98, Elmer Road, Middleton On Sea, Bognor Regis
Proposed Extensions & Alterations & Extended Parking Area
Application No. M/114/17/HH

Further to your e.mail communication dated 14th November 2017 I enclose two copies the following amended information as requested in your e.mial.

Ground Floor Plan ~ As Proposed

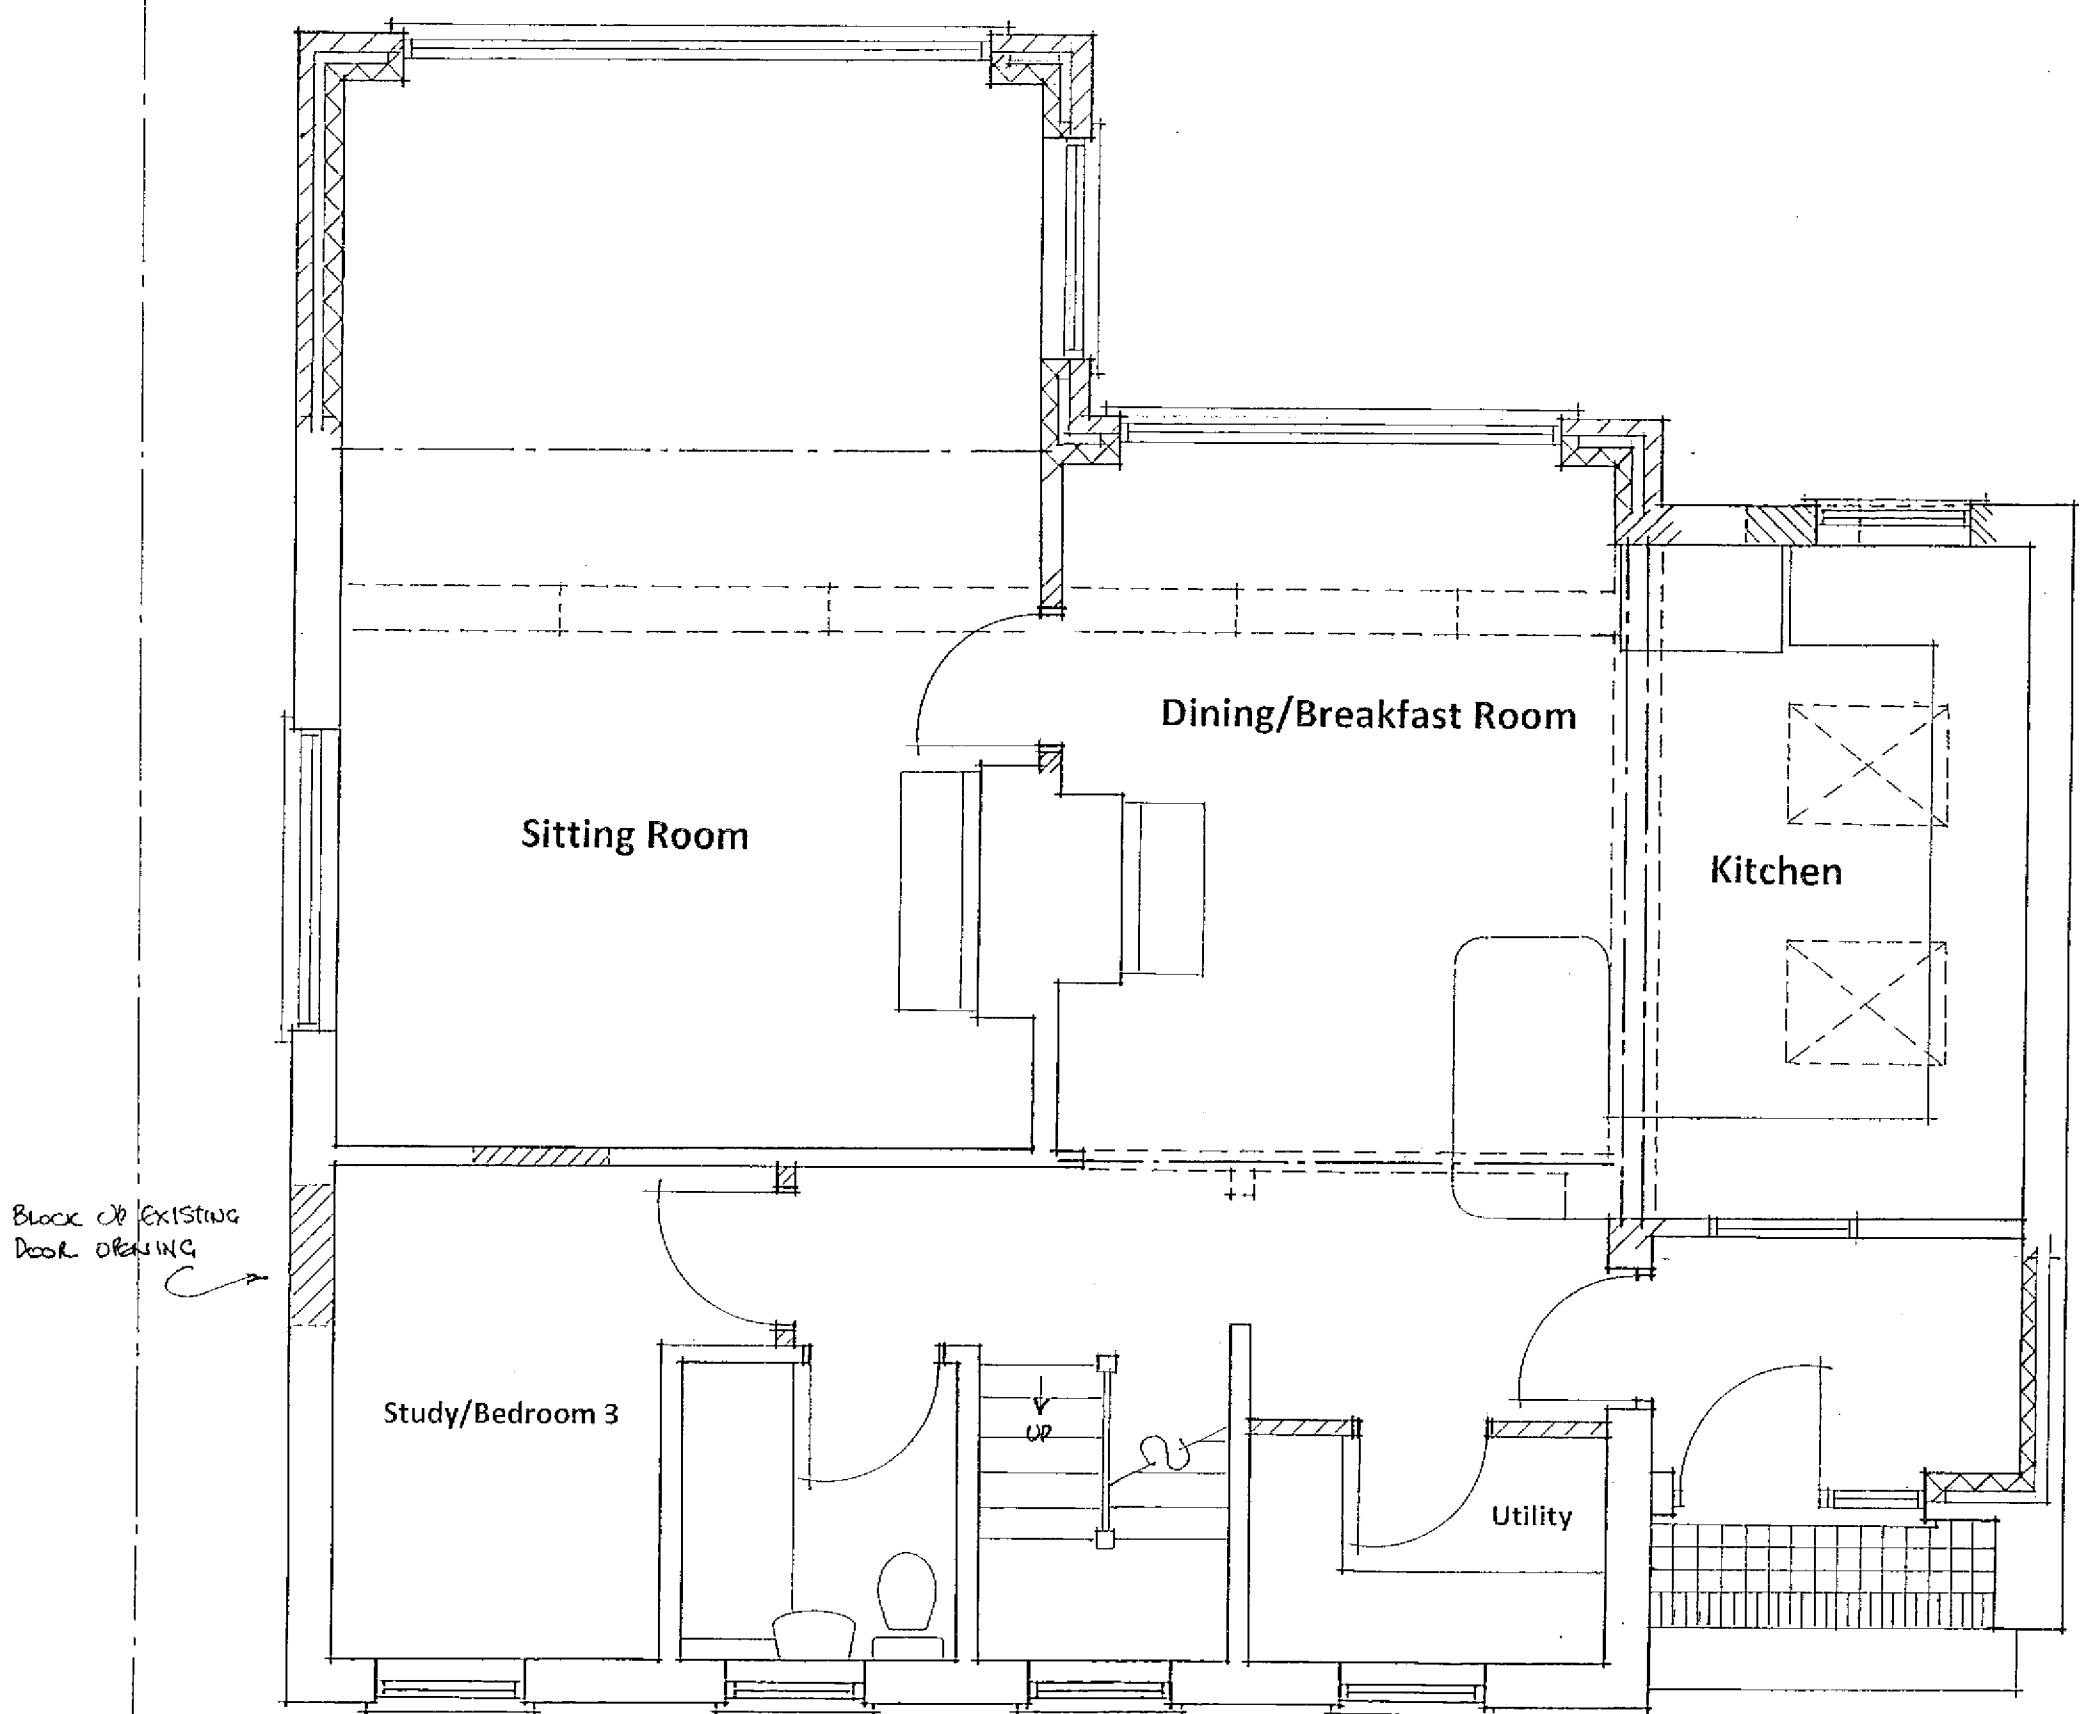
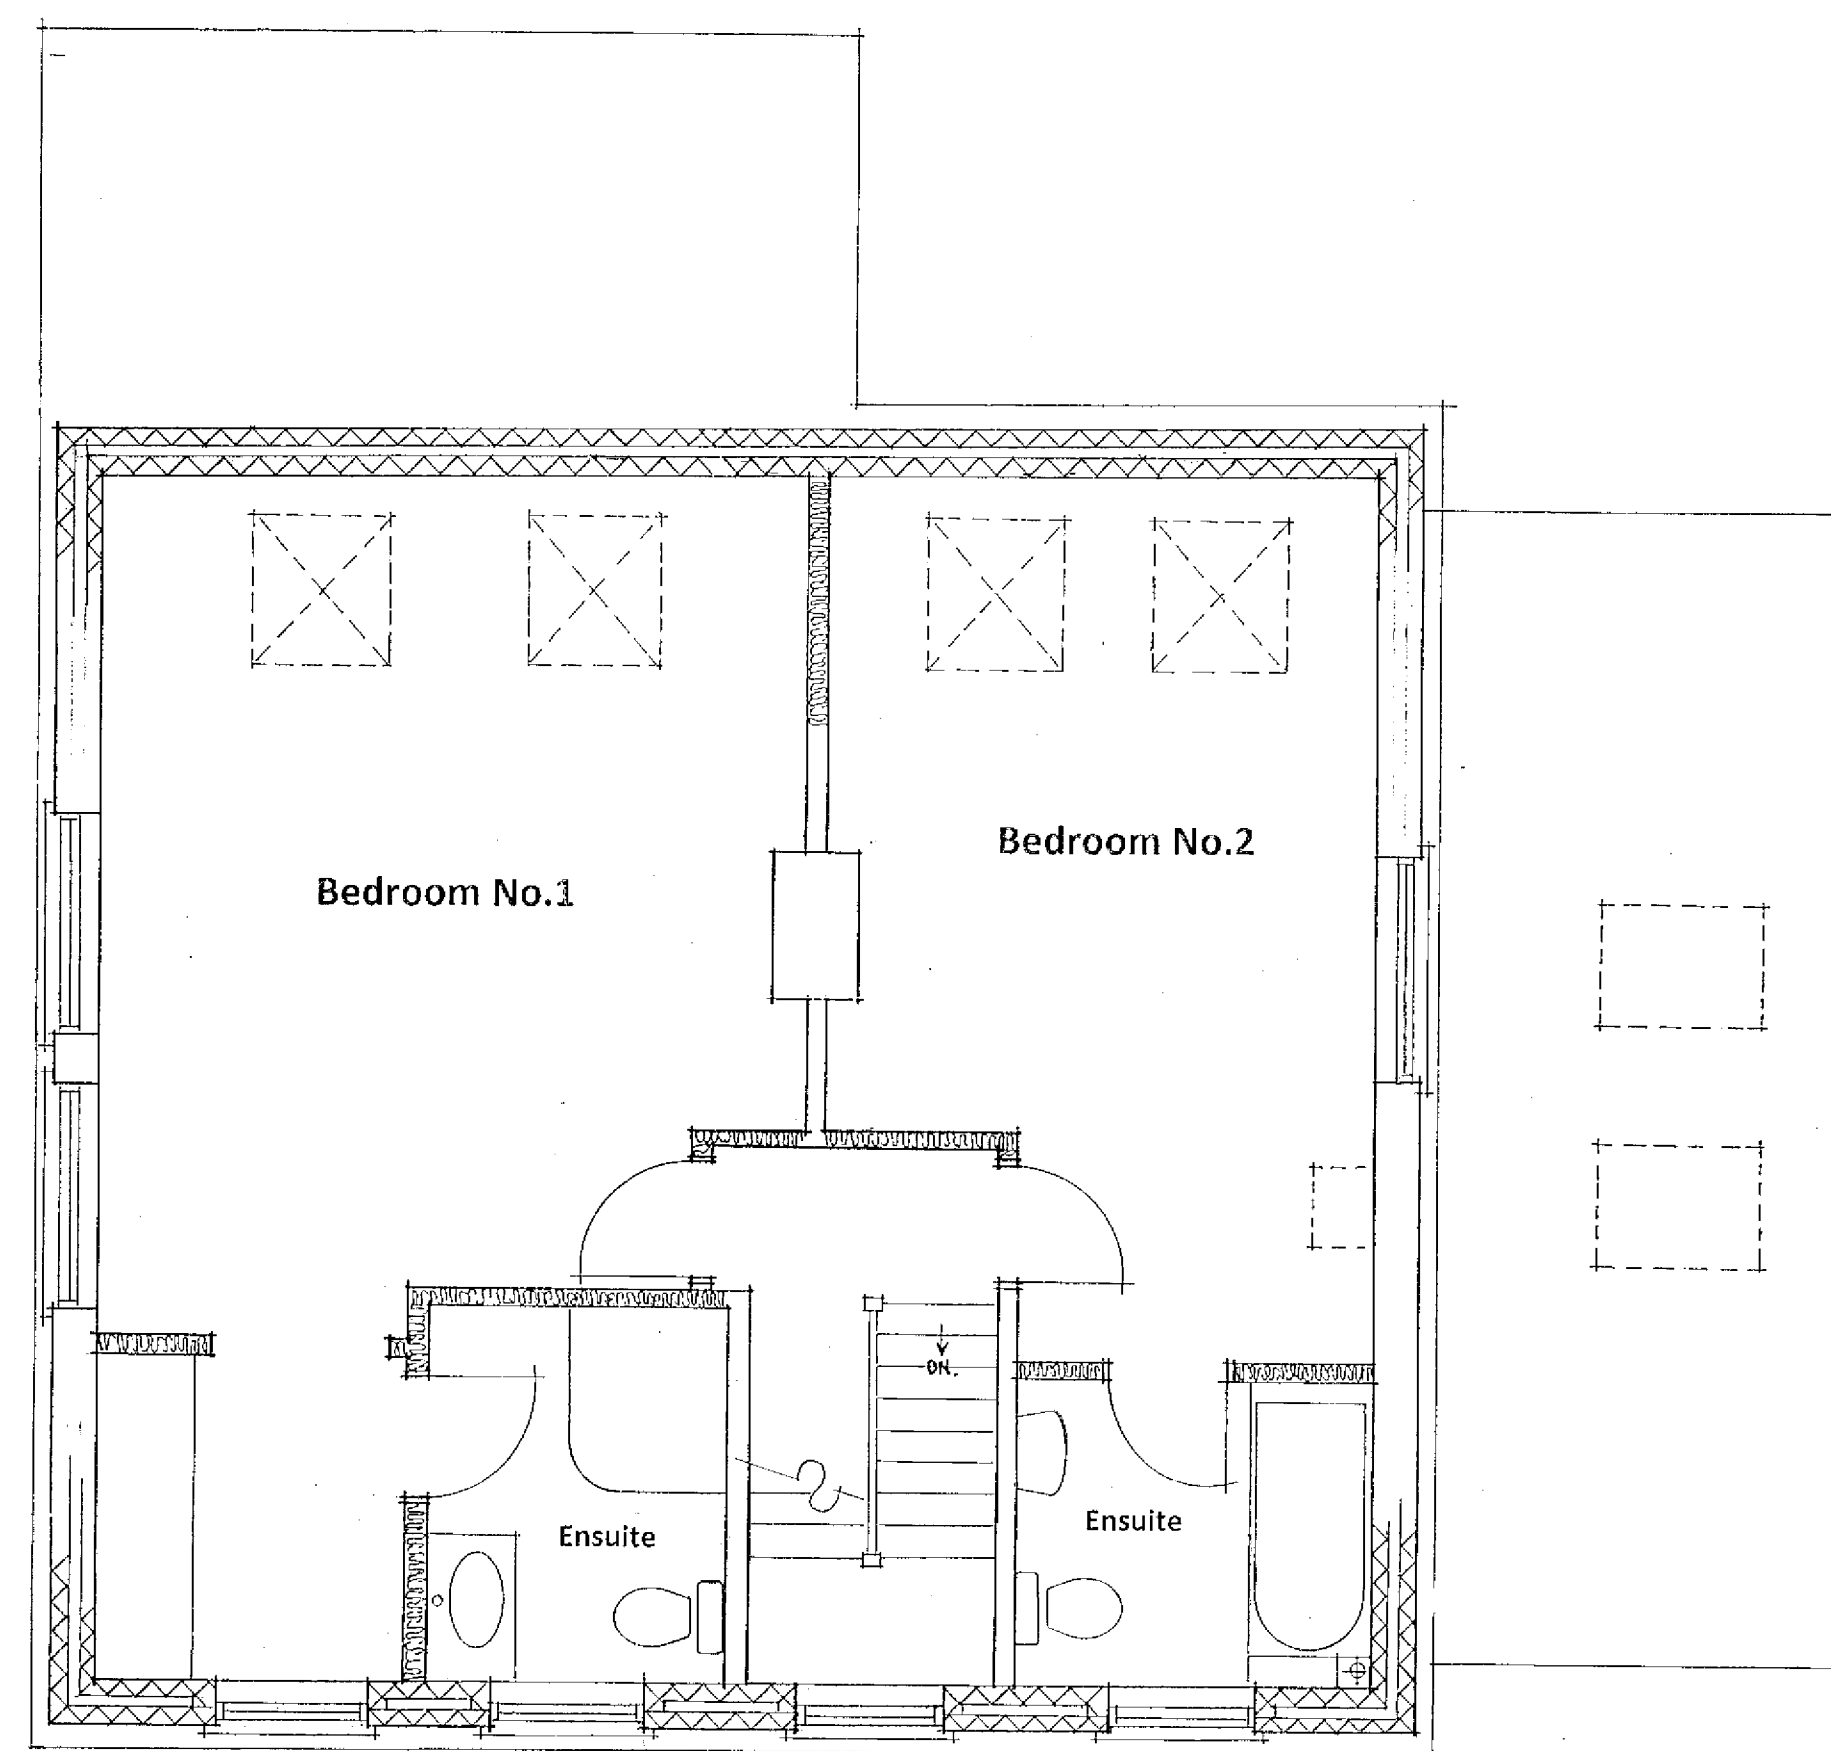
- 1) Block Plans showing distances to boundaries.
- 2) Proposed elevations with the correct orientations added.
- 3) Existing Ground Floor Plan amended with the staircase window shown.
- 4) Proposed ground/first floor plan amended with the staircase window shown.
